RE: East Platte Subdivision
PCD File No.: VR-17-014
Review Comments received December 26, 2017

EAST PLATTE SUBDIVISION

A VACATION AND REPLAT OF LOT 1, CIMARRON SOUTH FILING NO. 1
LOCATED WITHIN THE NORTHEAST 1/4 OF SECTION 18,
TOWNSHIP 14 SOUTH, RANGE 65 WEST OF THE 6TH P.M.
COUNTY OF EL PASO, STATE OF COLORADO

EAST PLATTE SUBDIVISION

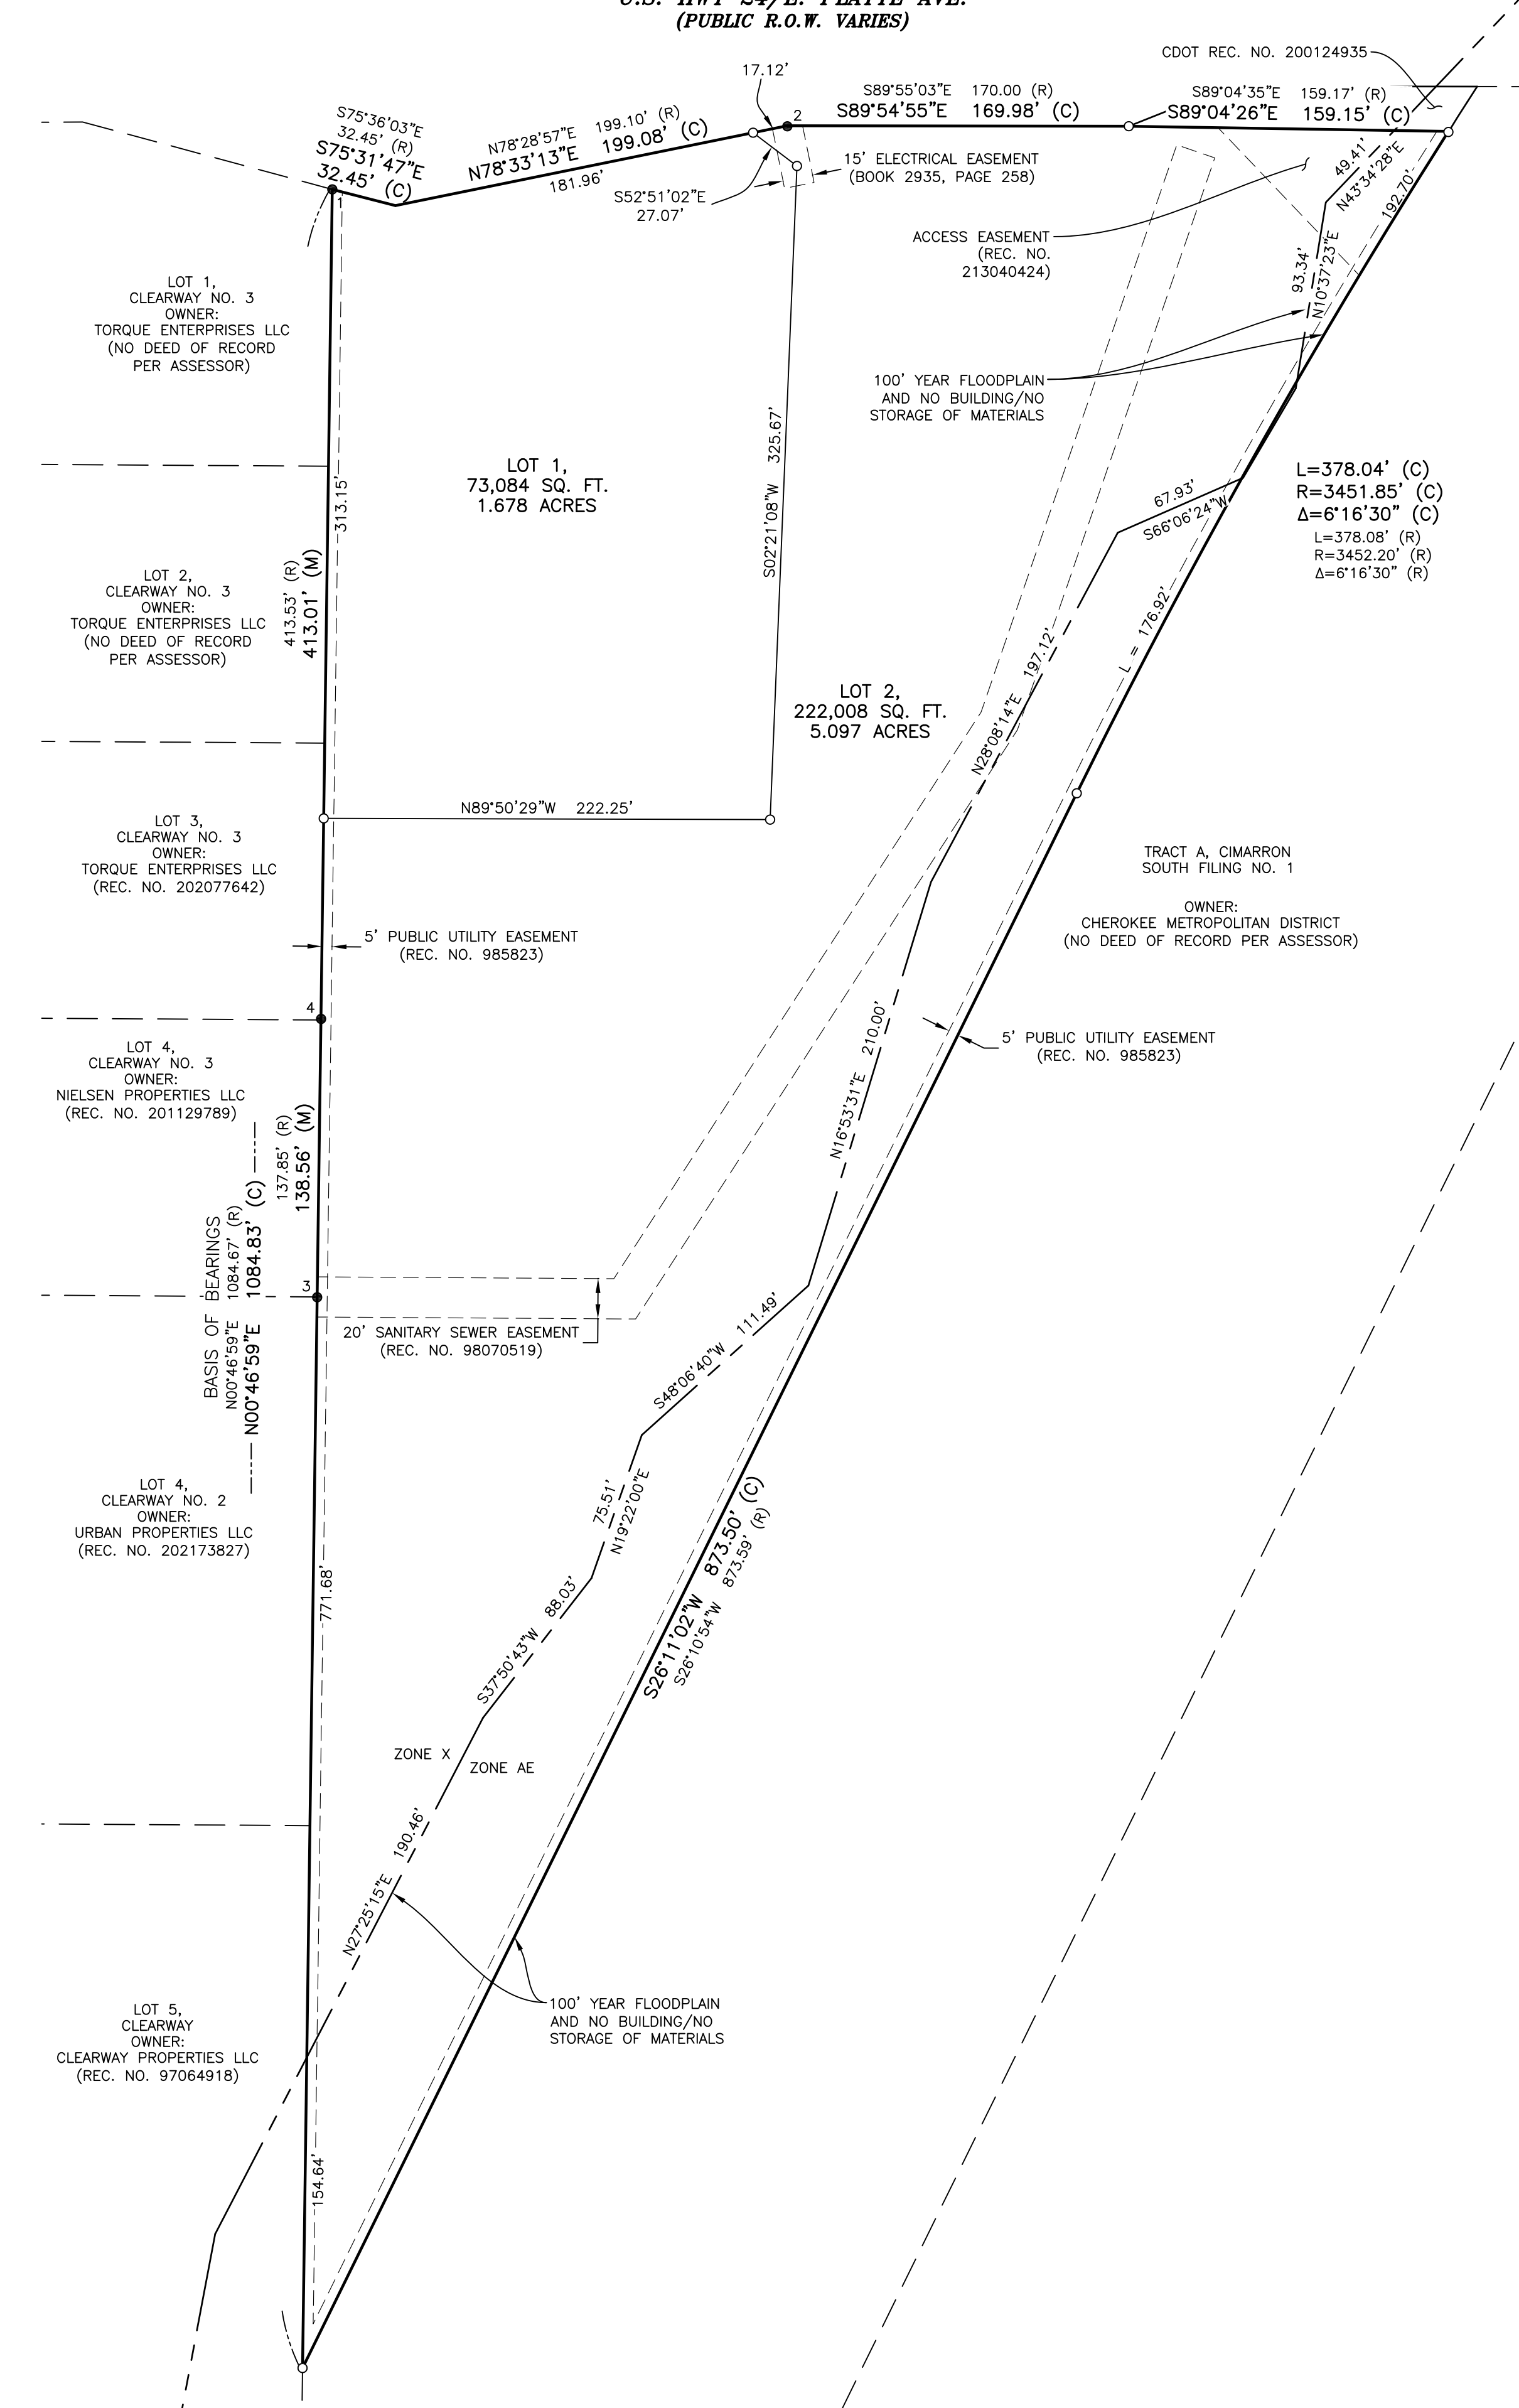
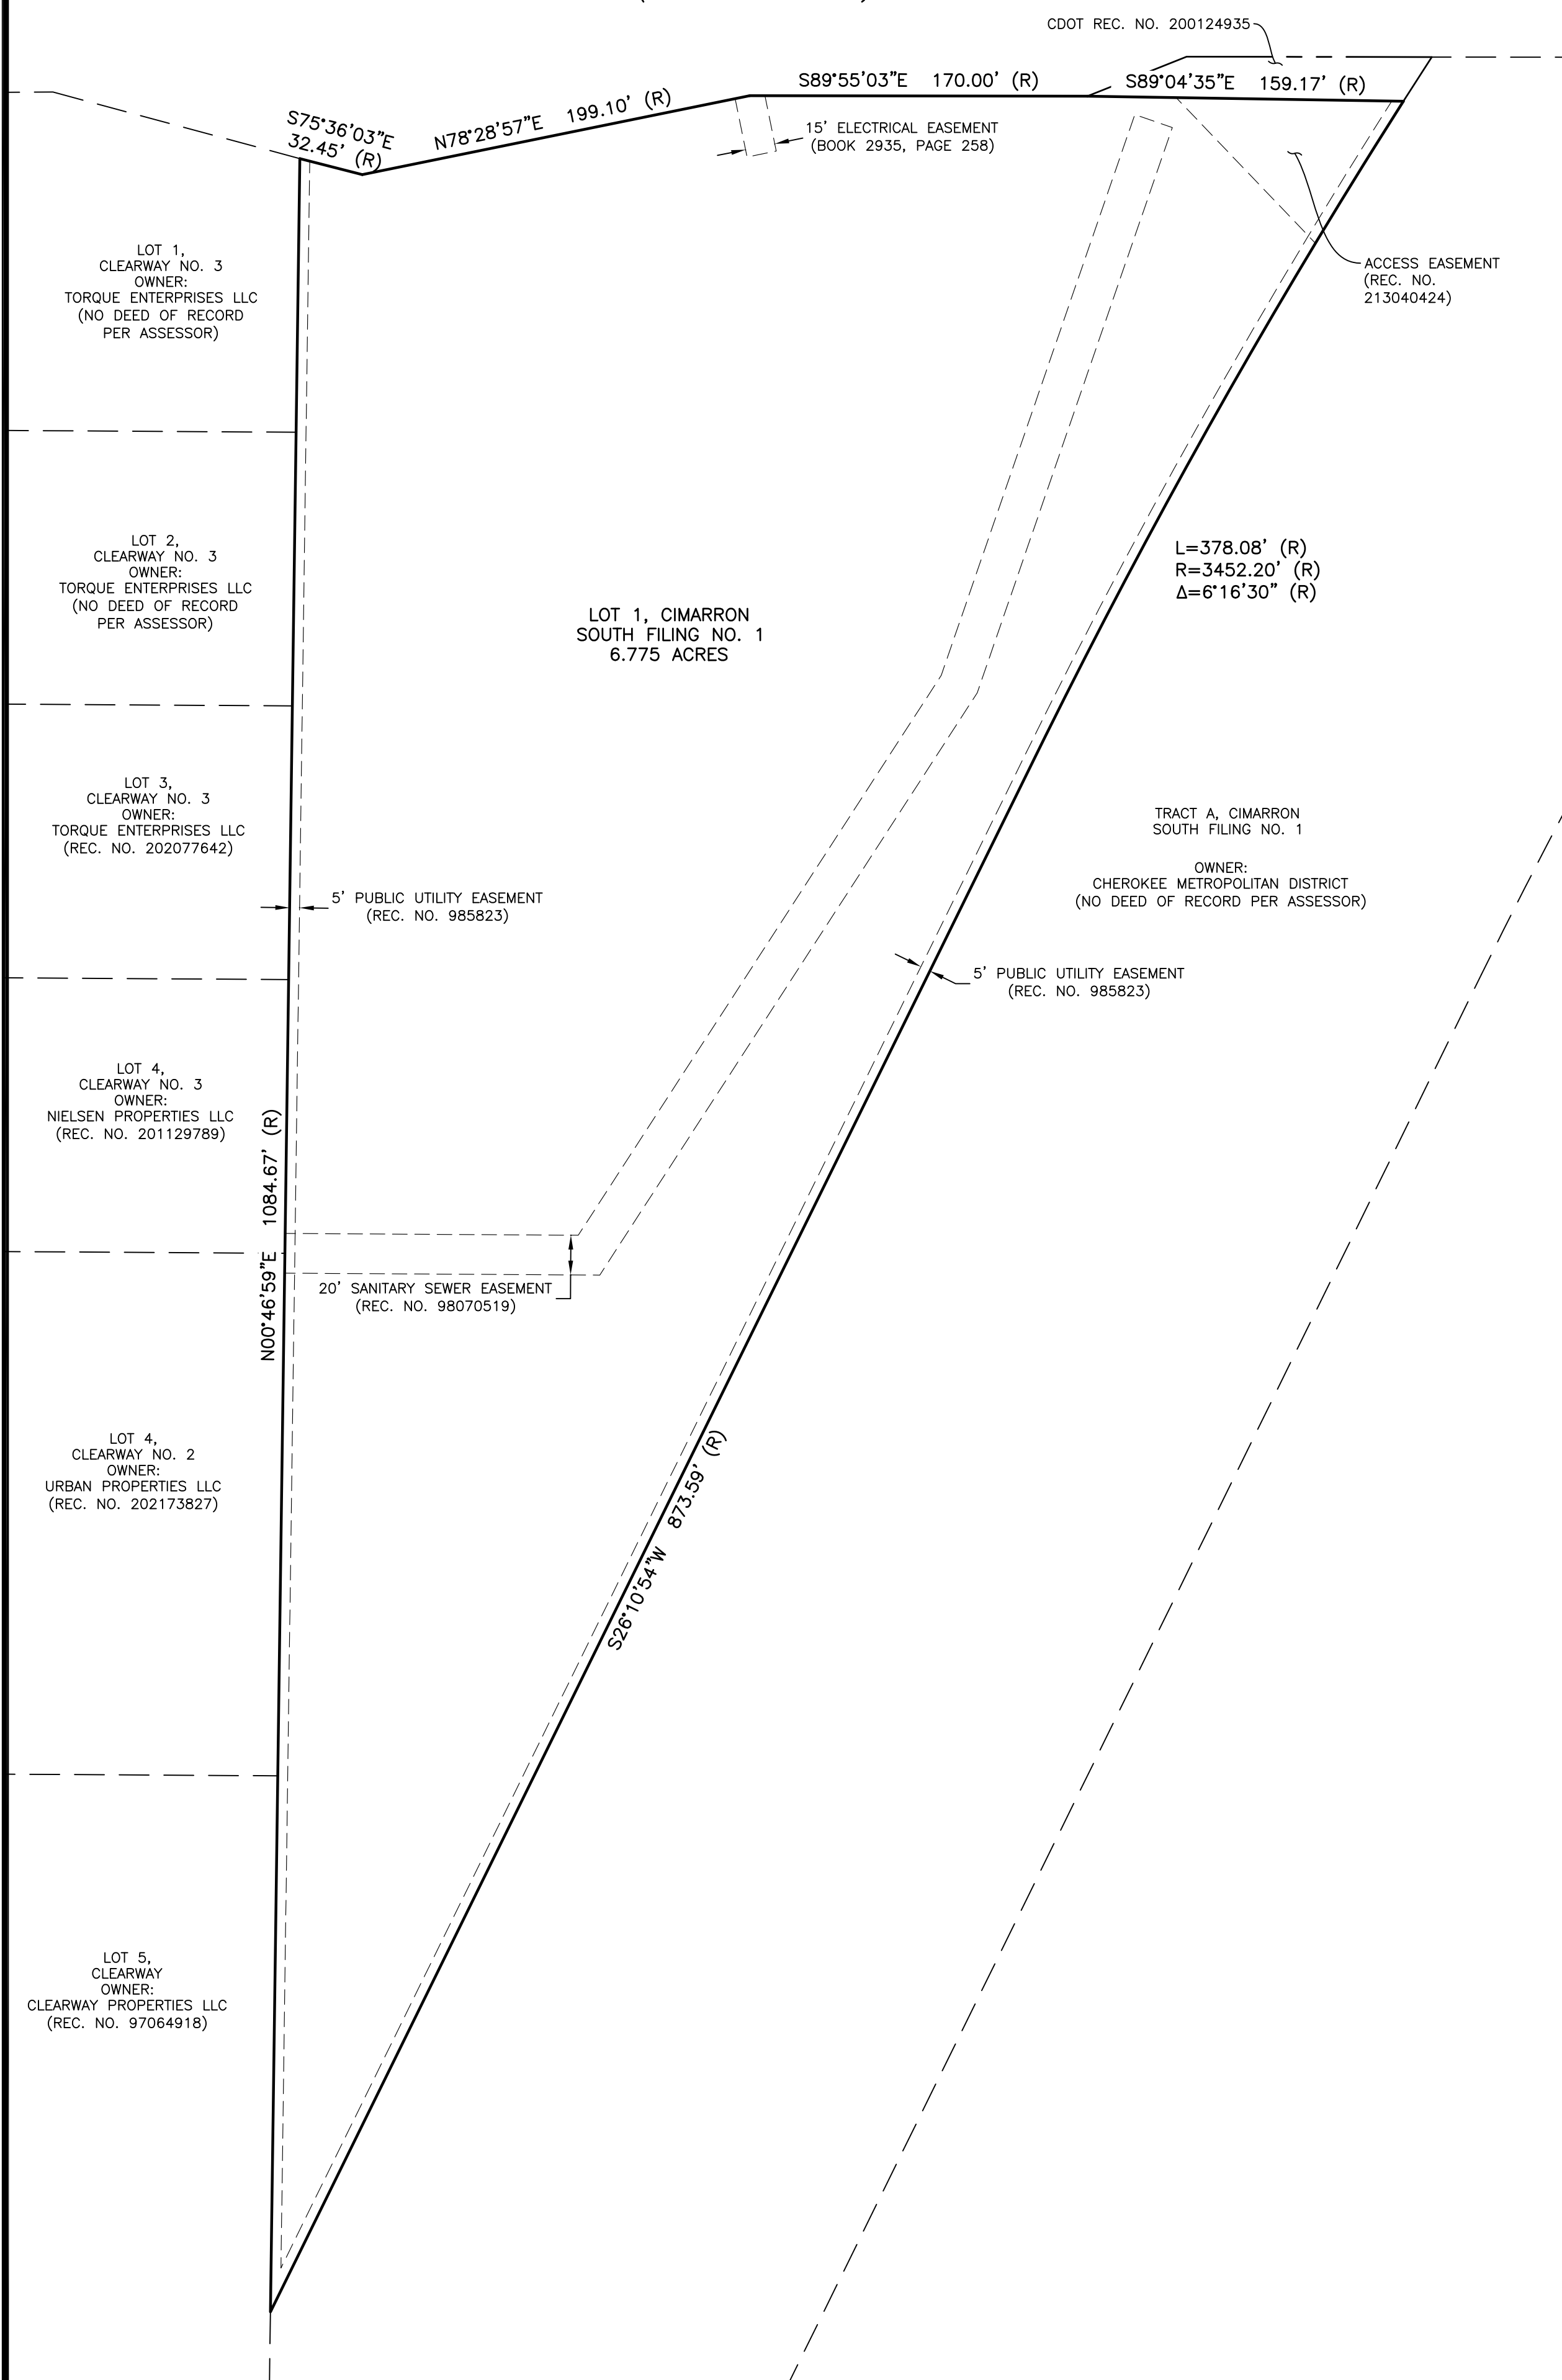
Show the FEMA Floodplain and base flood elevation.
100yr floodplain within Lot 2 must be placed within a "No Build/No
Storage of Materials" easement.

Review 2: Unresolved. Portions of the Floodplain encroaches
within the property. Per LDC Chapter 8 Section 8.4.2.B.1.e
"FEMA approved base flood elevation data and 100-year
floodplain boundaries shall be shown on the plat."
Also, provide a drainage easement for the 100yr floodplain
with the restrictions of "No Build" and "No Storage of
Materials" per LDC Section 8.4.2.B.1.d.

This does not match the as platted condition.

All comments have been revised and addressed per the PDF of the final plat markup, except for addressing the floodplain note. It is the surveyor's determination that the floodplain does not exist on the subject parcel based on elevations at the time of survey compared to the elevations of the floodplain as shown in the LOMR. Please contact Stewart Mapes at 719.766.9076 to ask any questions regarding the floodplain note as shown on the final plat.
